Letter of Intent for Special Use Permit

Re: Application for Special Use Permit – Accessory Metal Building (40' x 80' x 16') on 4.77-Acre Parcel, Zoned RR-5.

Property Address: 625 Slocum Road, Colorado Springs, CO 80830

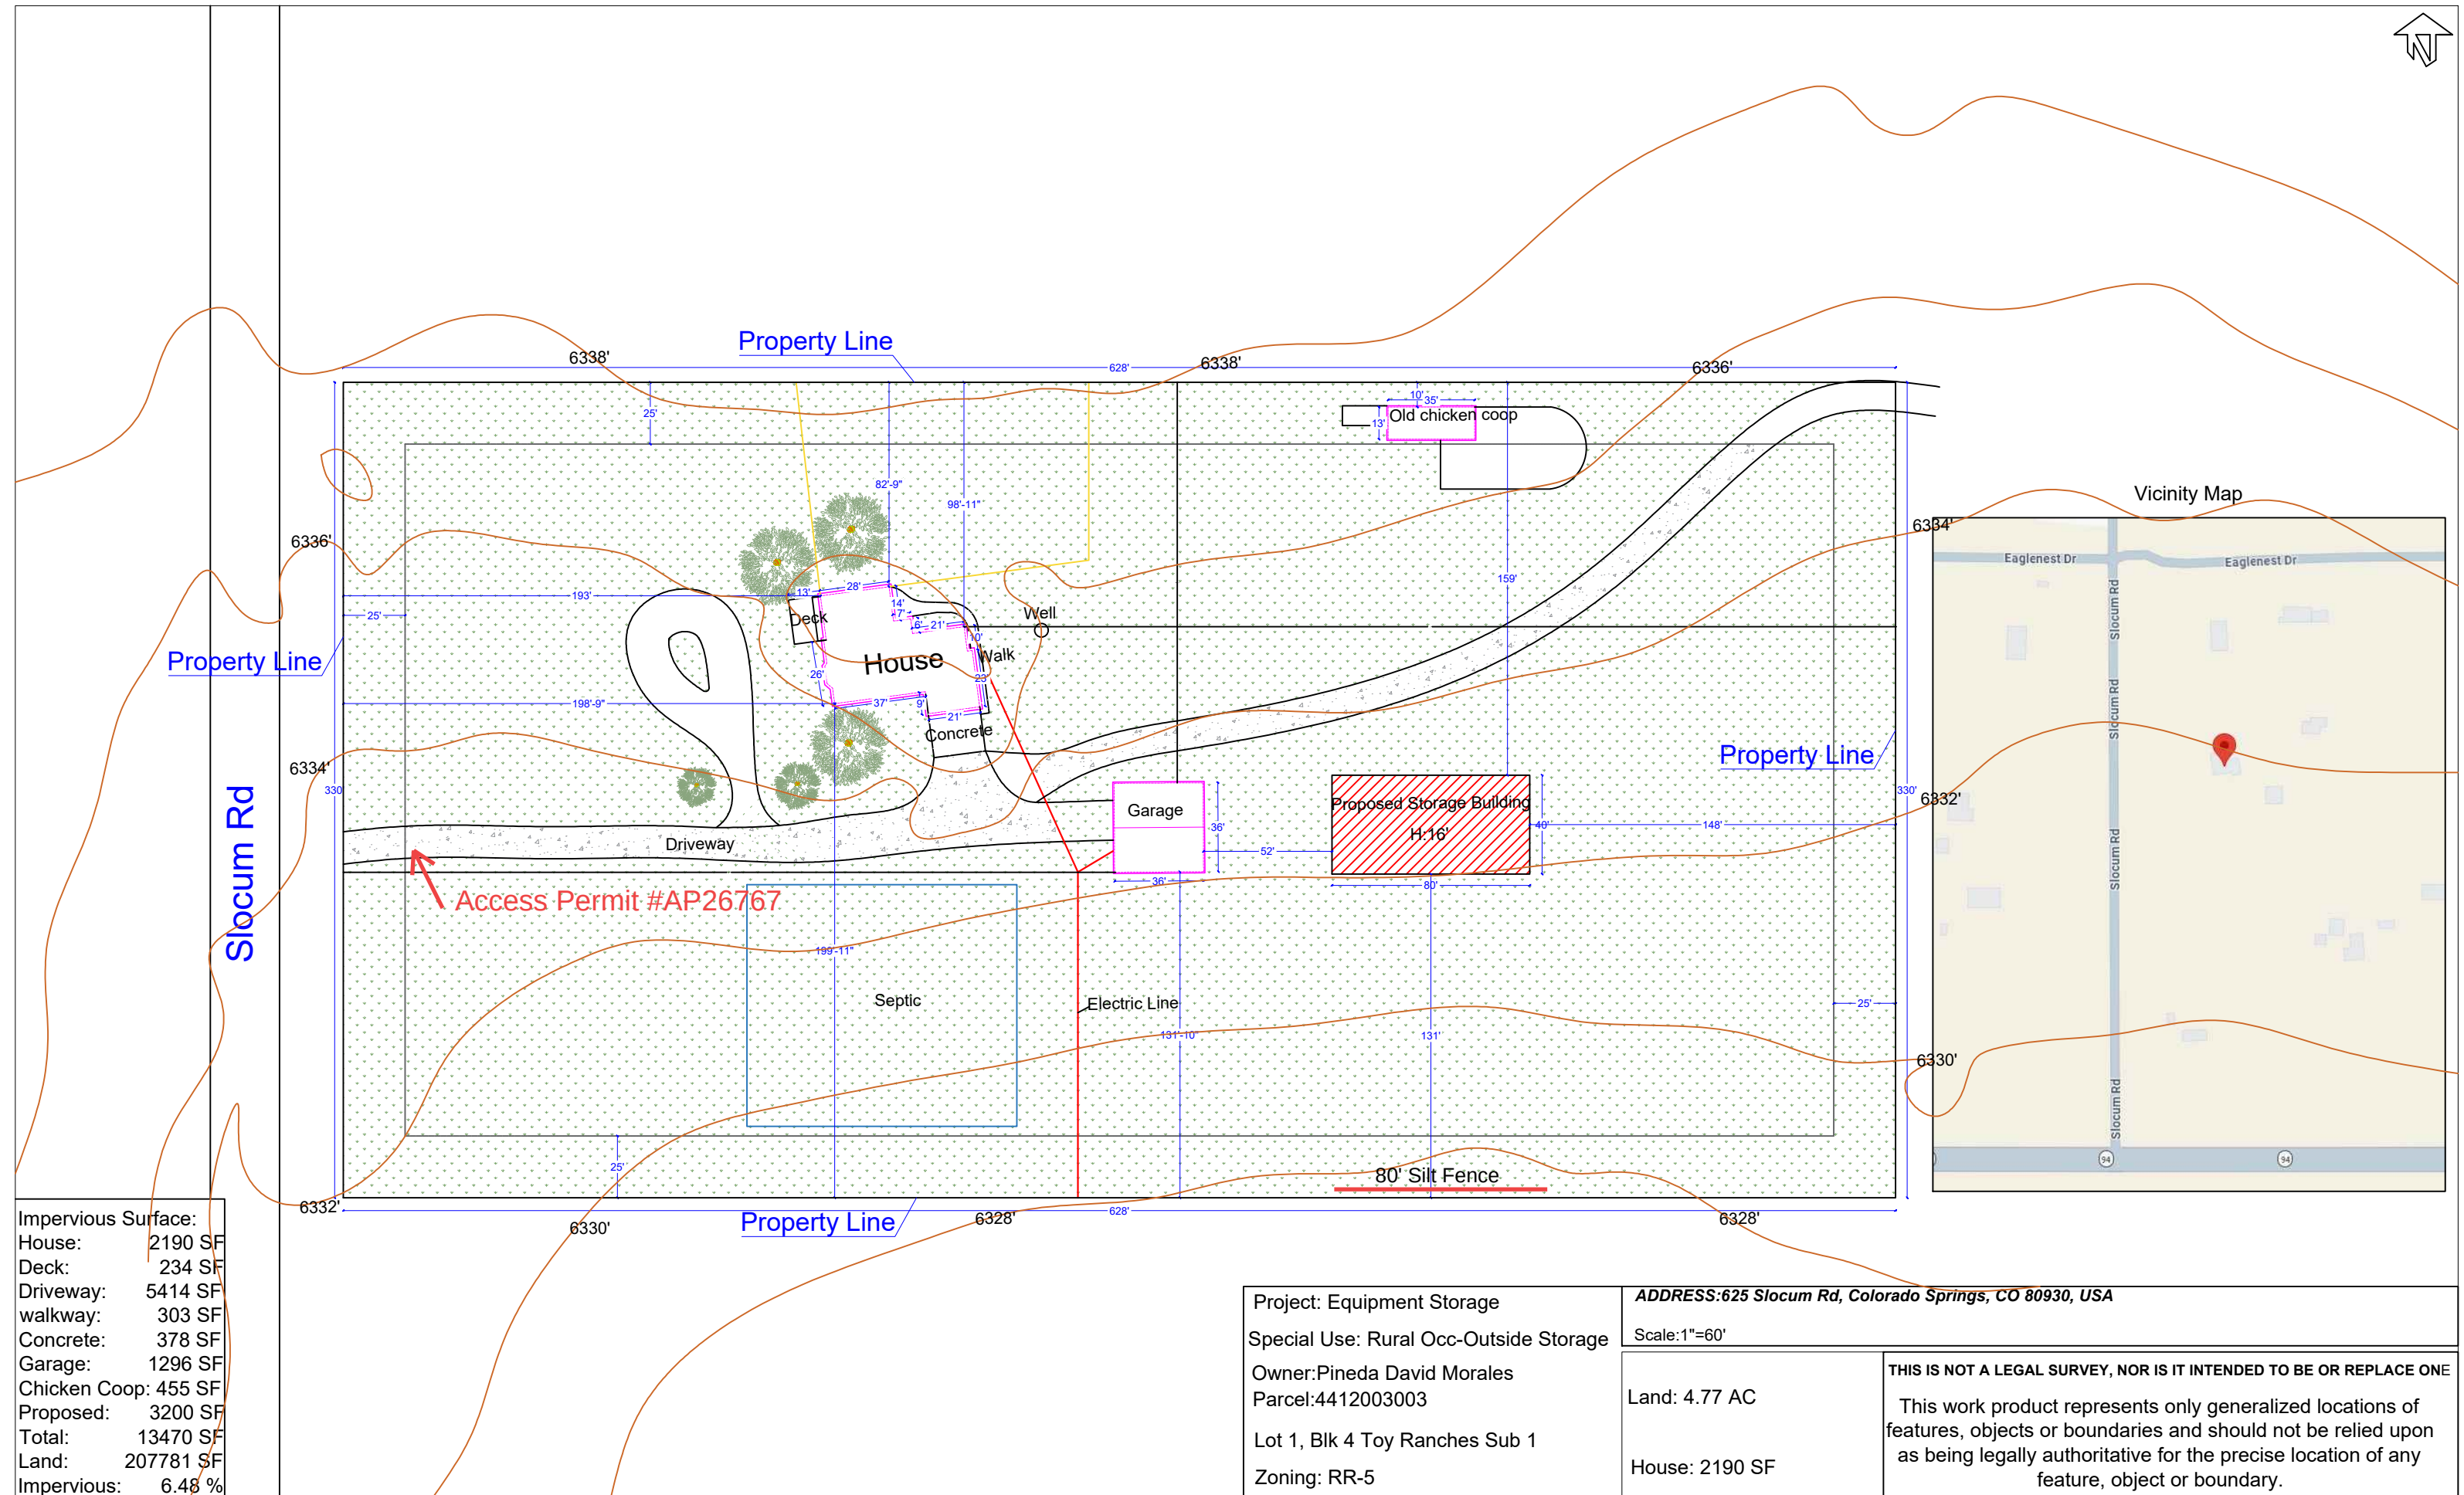
- **Mitigation of Impacts:**
 - Visual screening via existing topography/vegetation or added landscaping/fencing as needed. Is there fencing/vegetation proposed or not?

- No exterior lighting or signage proposed beyond safety requirements. Is there lighting proposed or not?
 - Stormwater managed on-site with no floor to allow natural percolation. 80' silt fence to be installed along southern boundary fence parallel to proposed building as a precautionary measure. Please provide details
